ASSESSMENT REPORT

GOSFORD HOSPITAL SSD 6913 MOD 1

PROJECT
GOSFORD HOSPITAL
HOLDEN STREET GOSFORD, NSW 2250
DRAWING NUMBER
GHR-MW-DWG-AR- GHR-MW-DWG-AR-09605
DRAWING NAME
ARCHITECTURE ELEVATIONS - NORTH

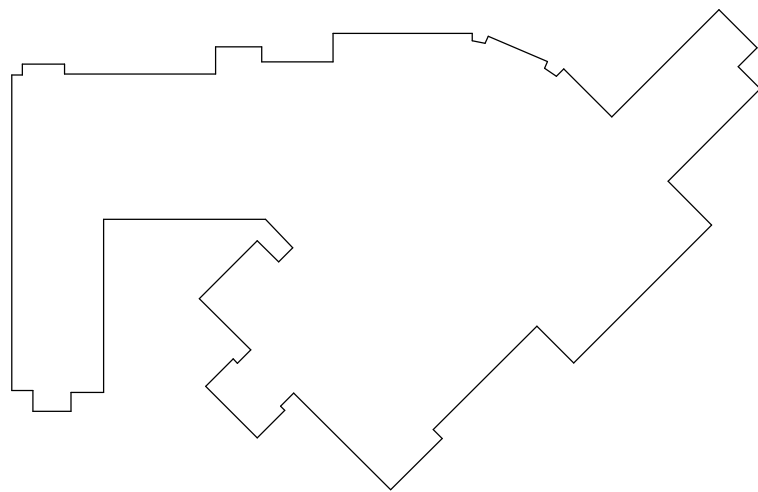
The Department has assessed the potential impacts associated with the proposal and considers that the reduction in building height would slightly reduce the visual scale of the building and therefore would have a positive visual impact on the surrounding area. Shadow diagrams submitted with the modification also demonstrate that the lower building height would result in a minor reduction in the level of overshadowing to nearby residential properties compared to the approved development.

The Department has also assessed the changes to the façade treatment and mix of materials and finishes. It is considered that the proposed changes would present a more contemporary façade design, and the wide range of finishes would appropriately break up the mass of the building, introduce a more human scale around the entrances and pedestrian areas and result in a positive impact on the streetscape.
